Our Ref: BE/1/18/HH
Your Ref:

Town & Country Planning Act 1990 (as amended)
Town & country Planning (Development Management Procedure) (England) Order 2015
Application for Planning Permission for Works or Extension to a Dwelling

Development Wrought iron effect railings & revised entrance access gates.
Location 8 & 9 Addison Way Bersted

LOCATION PLAN - 1/1250

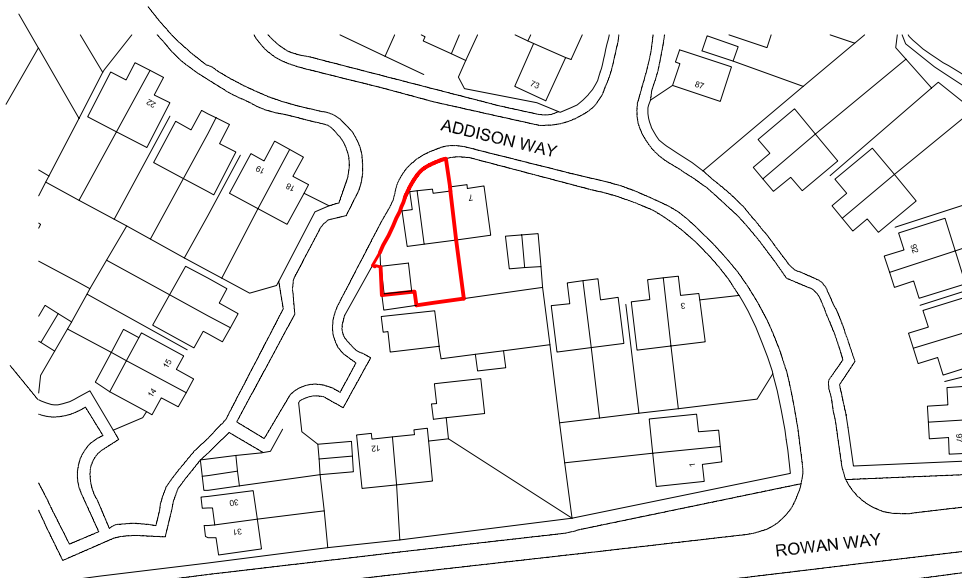
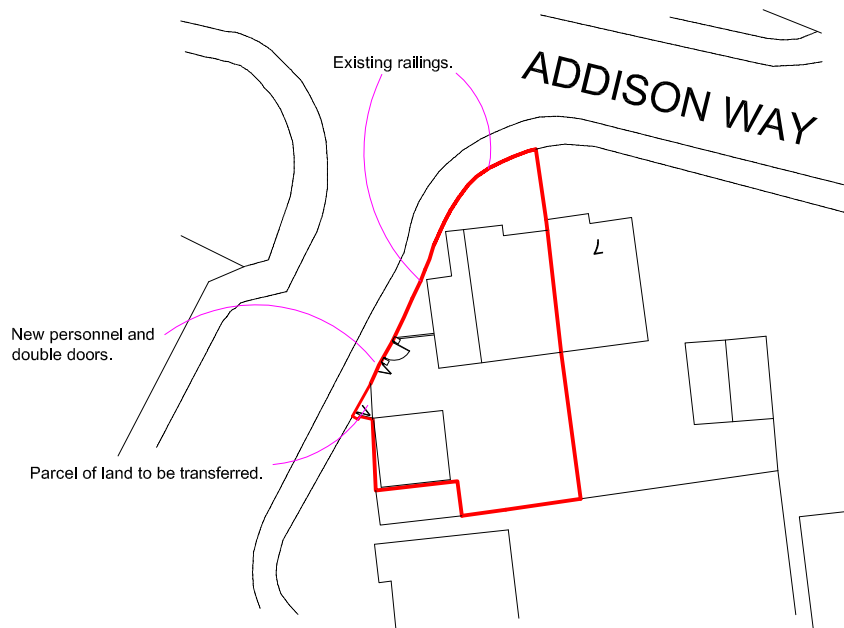
Please include the small piece of land at 9 Addison Way within the red edges on the location and block plans.
